DRB Application No.: **04DRB-01877 (P&F)**

Project Name: **Sandia Hills**

**CITY OF ALBUQUERQUE  
PLANNING DEPARTMENT  
DECEMBER 15, 2004  
DRB Comments**

**RE: Lot 44, Sandia Hills/minor plat**

NOW COMPRISING LOT 44-A, SANDIA HILLS SUBDIVISION.

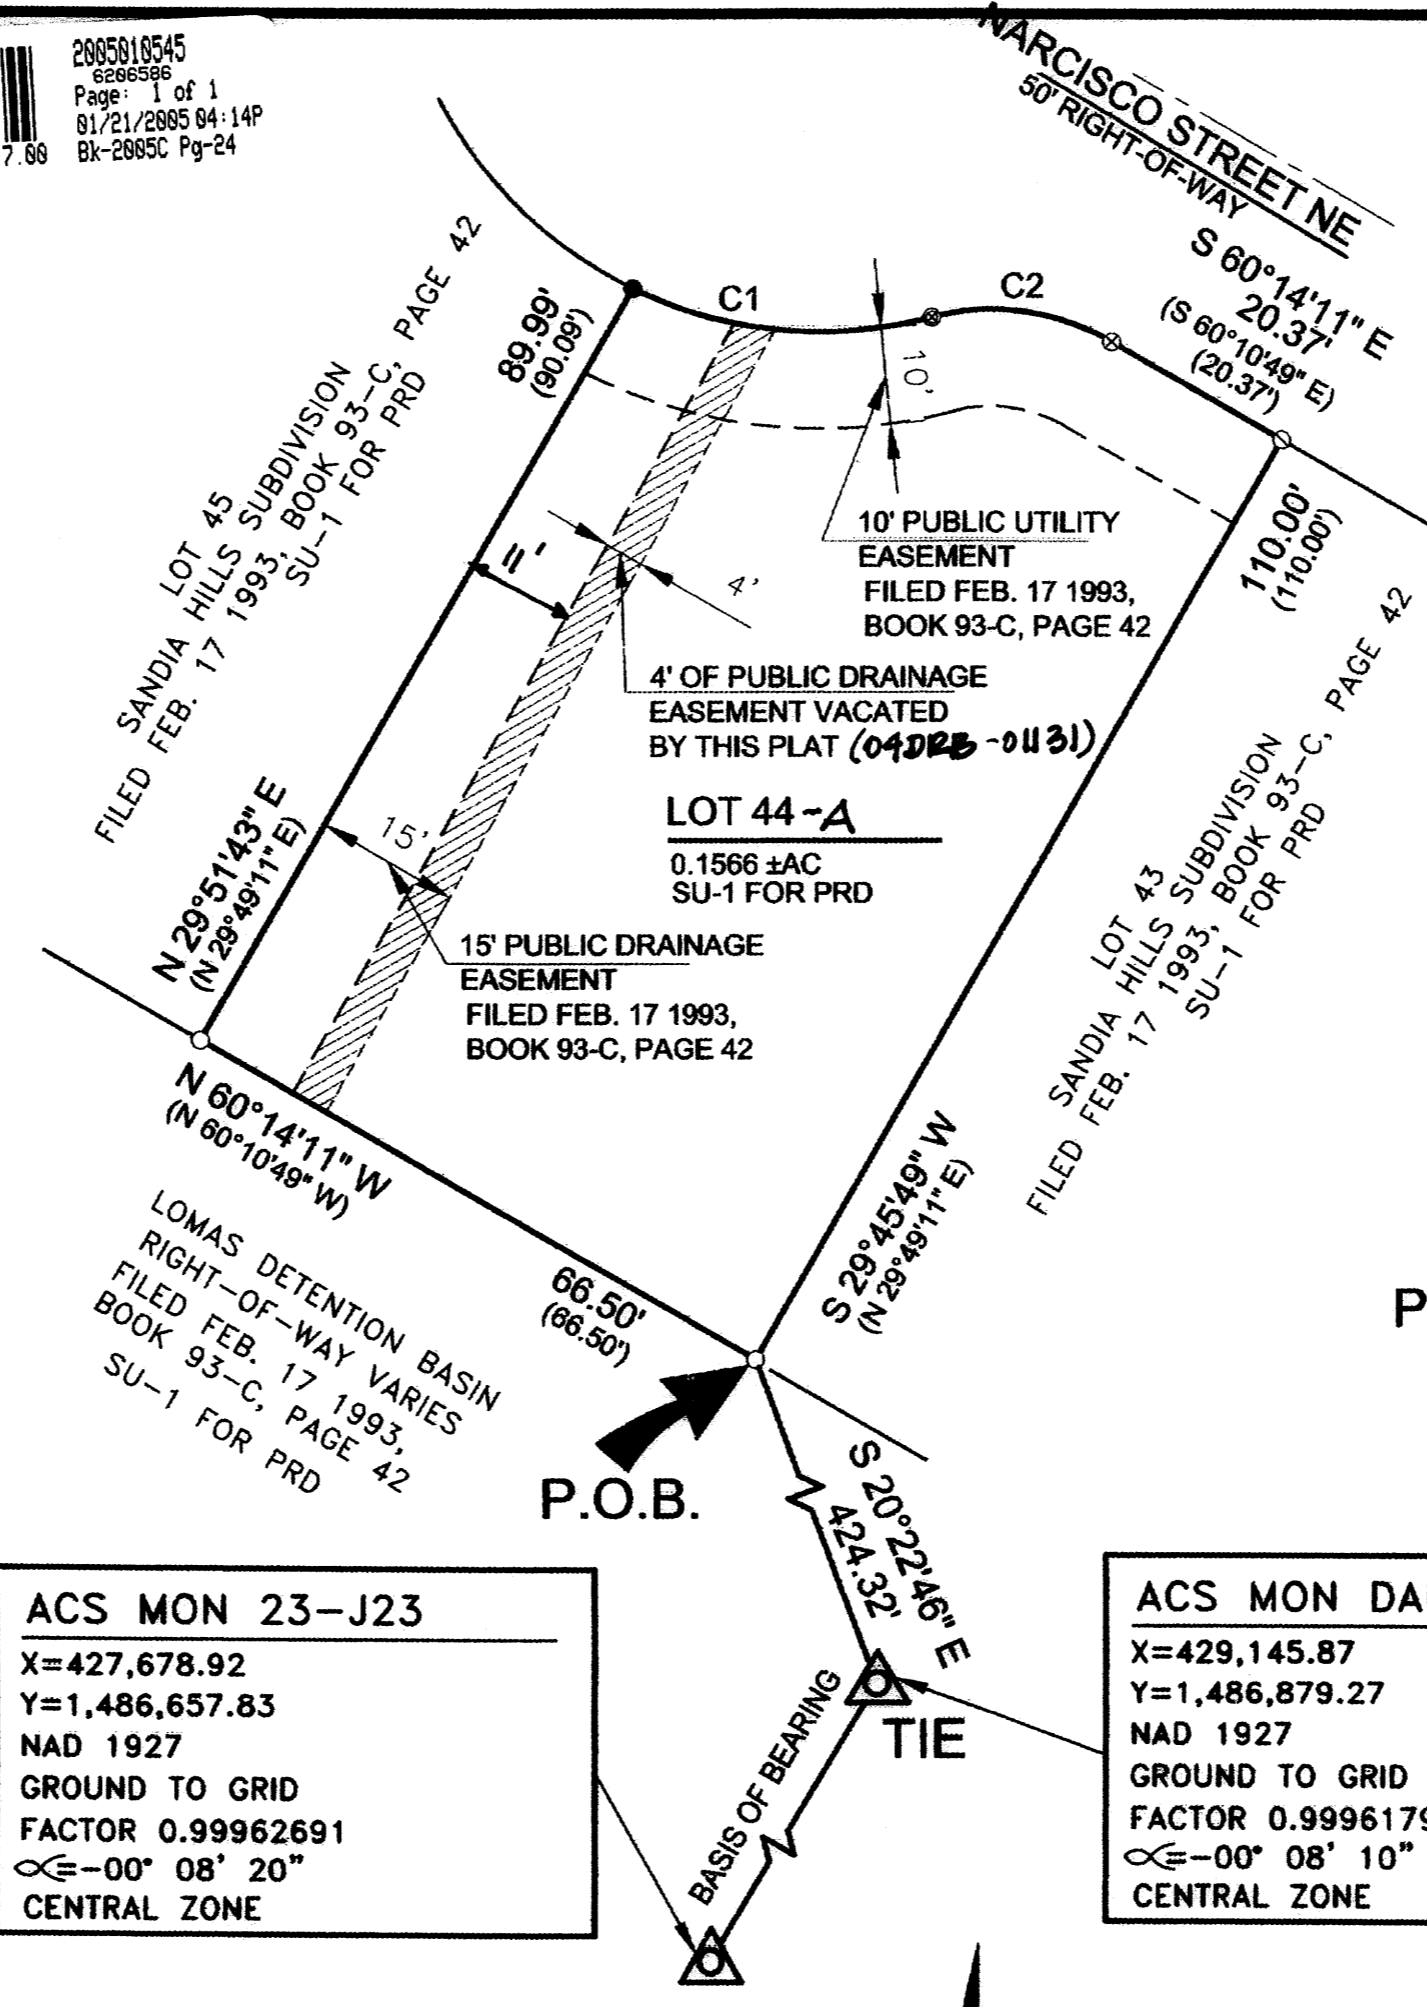
What is SU1 for PRV zoning? Is it perhaps SU1 for PRD?
